SPR EA1N and EA2 PROJECTS

DEADLINE 2 - COMMENTS ON ESC AND SCC JOINT LOCAL IMPACT REPORT

Interested Party: SASES

PINS Refs: 20024106 & 20024110

A12/A1094 FRIDAY STREET  
PROPOSED SIGNAGE LAYOUT

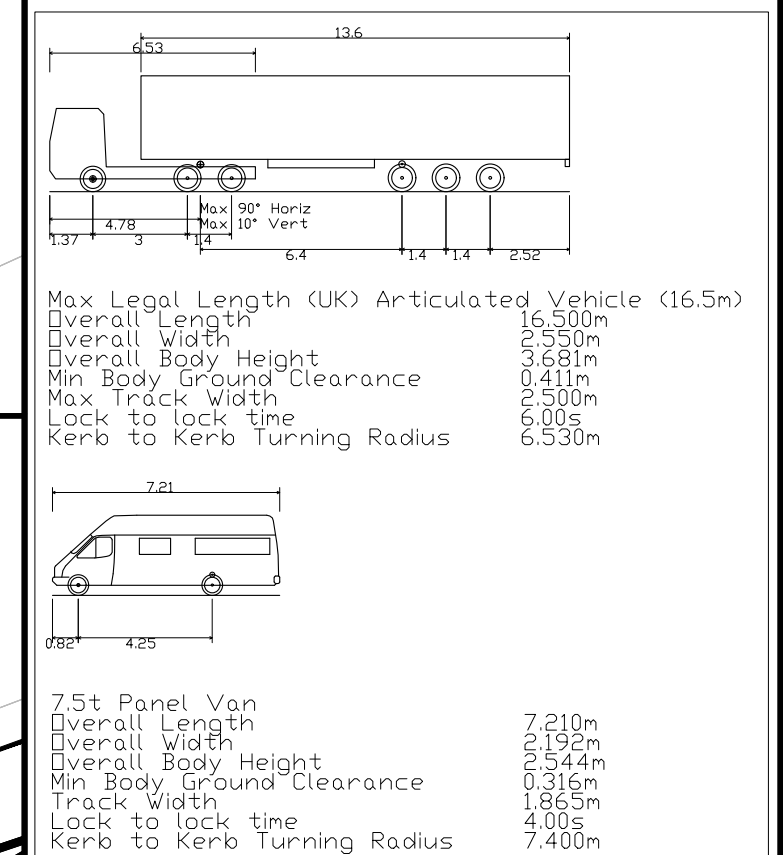
<p>Traffic and Transport</p> <p>21.46</p>		<p>Whilst temporary traffic signals may address safety issues there appears to be no analysis of the congestion impact of such signals given that they will regularly halt the traffic on the A12. Such congestion impacts would not only be felt at this junction but on local “rat run” routes and cause further congestion at the Snape crossroads on the A1094.</p> <p>Furthermore there is no analysis of how the construction works required for a new roundabout (see EDF proposals referred to in paragraph 21.47) at A12/A1094 junction will impact traffic flows and when. Clearly the construction of such a roundabout will cause congestion which would only be exacerbated by the traffic required to support the Applicant’s and National Grid’s projects.</p> <p>A very substantial new potato processing plant and a weighbridge and office development was consented by the Local Planning Authority on 23 April 2019. It is being built on the northern side of the A1094 near to the A12/A1094 junction. This</p>

<p>will create further HGV and other traffic. The implications for cumulative traffic and transport needs and forecasts must be thoroughly assessed, in particular with regards to safety and congestion.</p> <p>http://publicaccessdocuments.eastsuffolk.gov.uk/NorthgatePublicDocs/01440365.pdf</p> <p>On the southern side of the same junction there is a thriving farm shop and café which is currently building a substantial extension for a deli and staff area. There has been a steady increase in custom and cars at the Farm Shop and Café and they continue to expand. Further there are other businesses on the site which is increasingly becoming a retail destination very close to the A12/ A1094 junction. There is no formal junction at this site, traffic merely turns left and right off the highway. The future growth of this site and resulting traffic needs to be addressed.</p> <p><u>Operational Access Road</u></p> <p>It is a concern that the LIR does not address the future use of the up to 8m wide 1.7km long access road from the B1121 which has been identified as unsuitable for construction traffic. The future use of this road needs to be controlled so that by default it does not become a construction access road for future developments (e.g. by National Grid) at the substation site.</p>
